# Rezoning Transportation Analysis

Petition Number: #2022-218

General Location Identifier: 04118122 and 04118123

Date	Description
05-24-23	First Review (ME)

CONCEPTUAL SITE PLAN
REZONING PETITION #2022-218

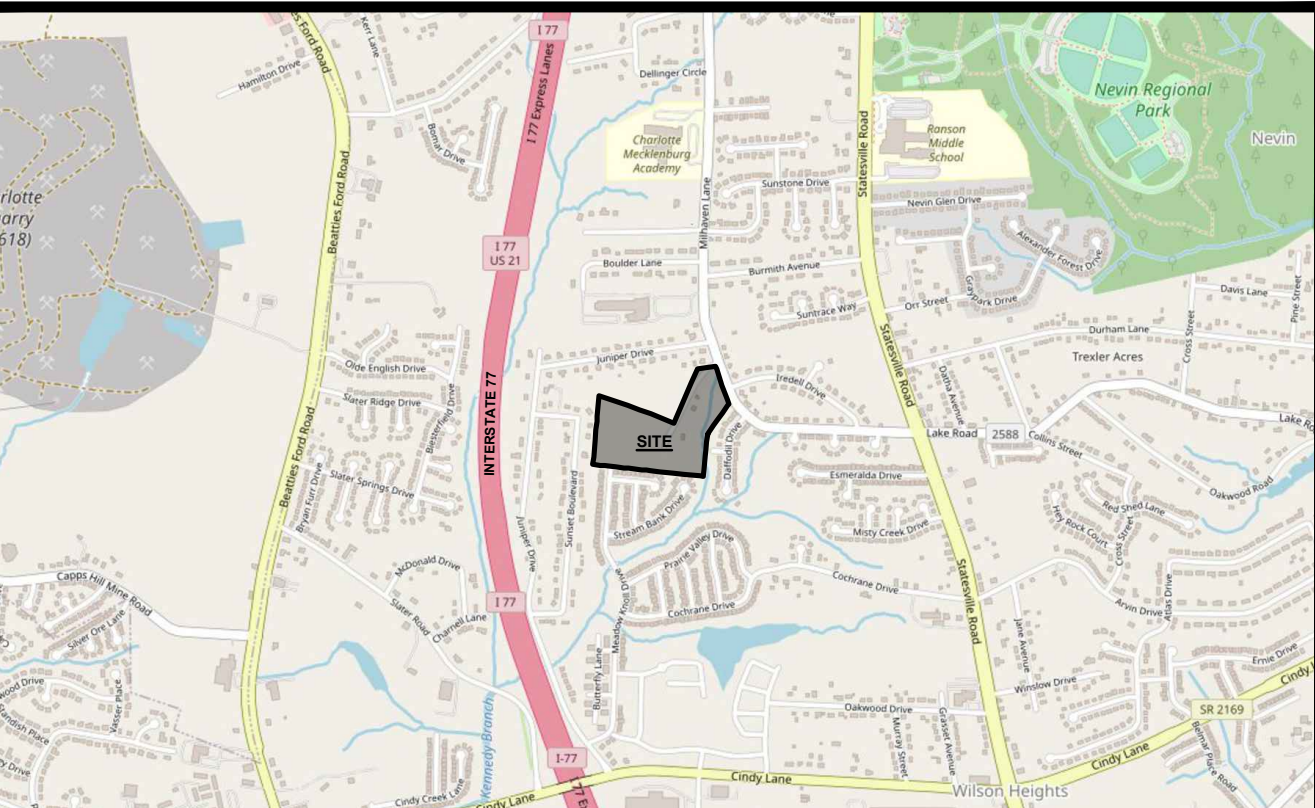
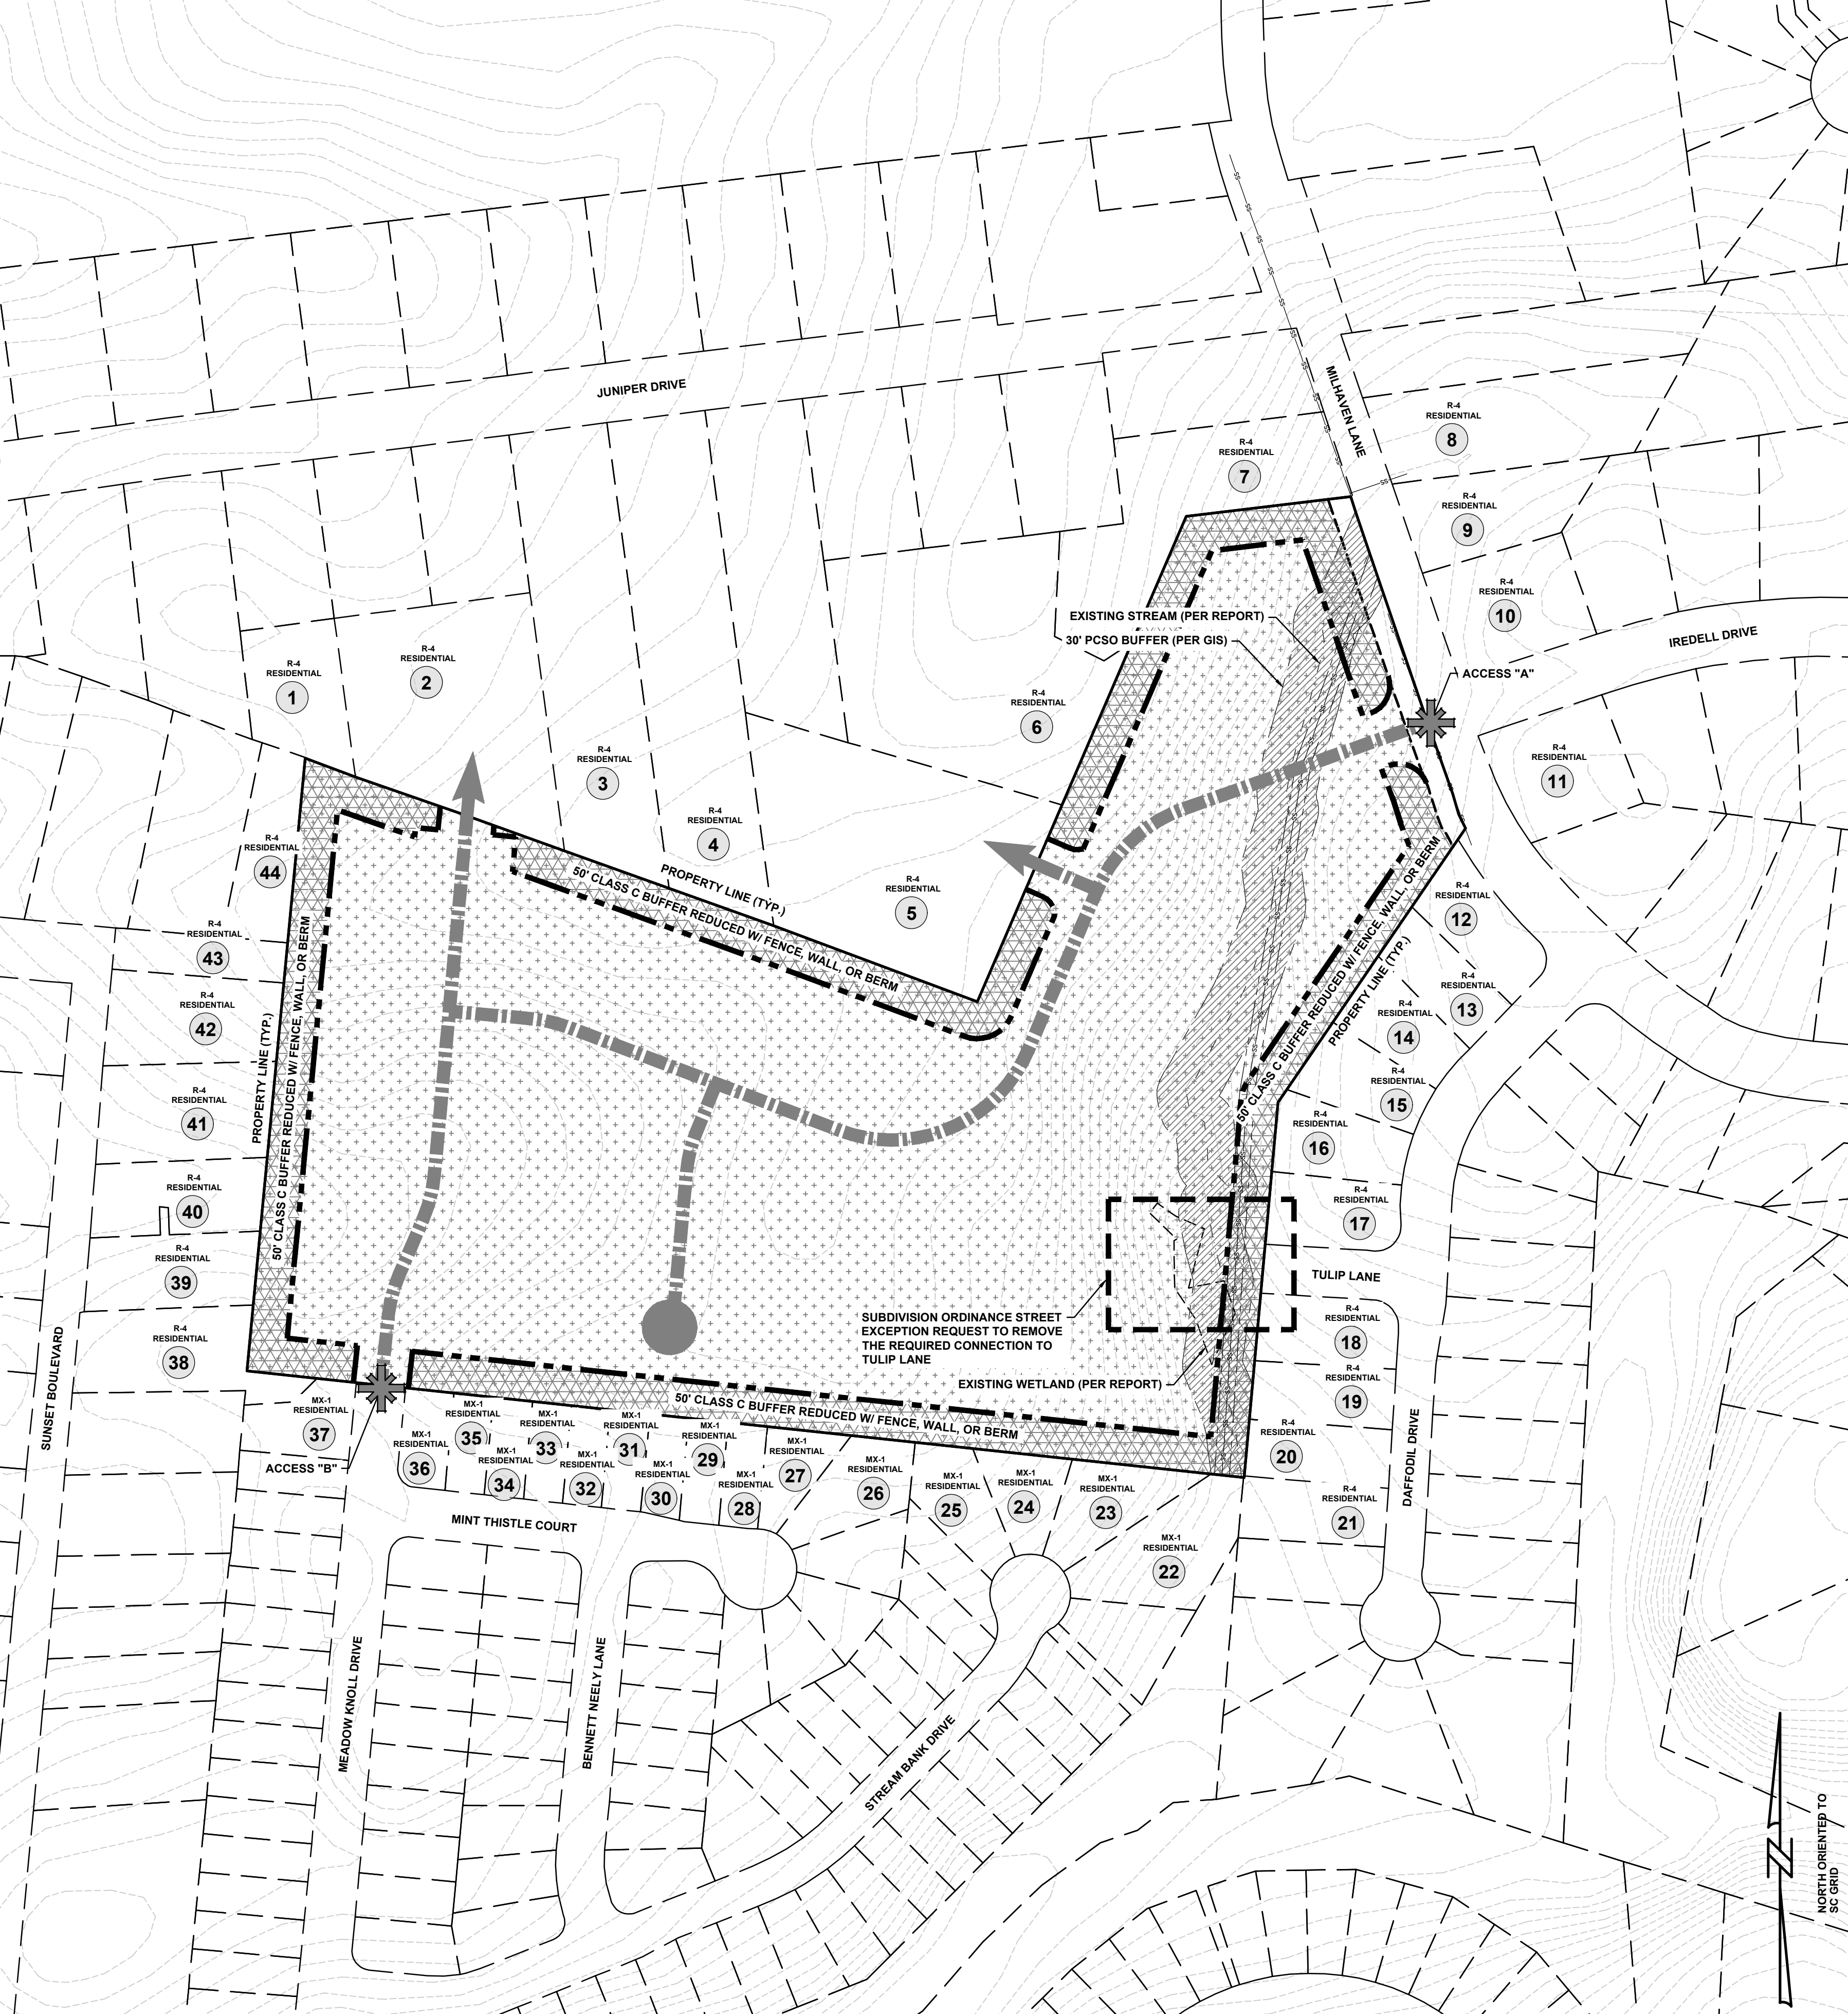
Label and dimension the curb and gutter from the centerline for each road on the site plan.

- Revise site plan and conditional note(s) to commit to dedicate 36 ft right-of-way from the road centerline. The site plan shall label and dimension the right-of-way from the road centerline.

- Revise site plan and conditional note(s) to commit to construct an 8-foot planting strip, and 5 foot sidewalk on Milhaven Lane per Chapter 19 / Chapter 20. The site plan shall label and dimension both items from the back of curb and gutter or edge of pavement.
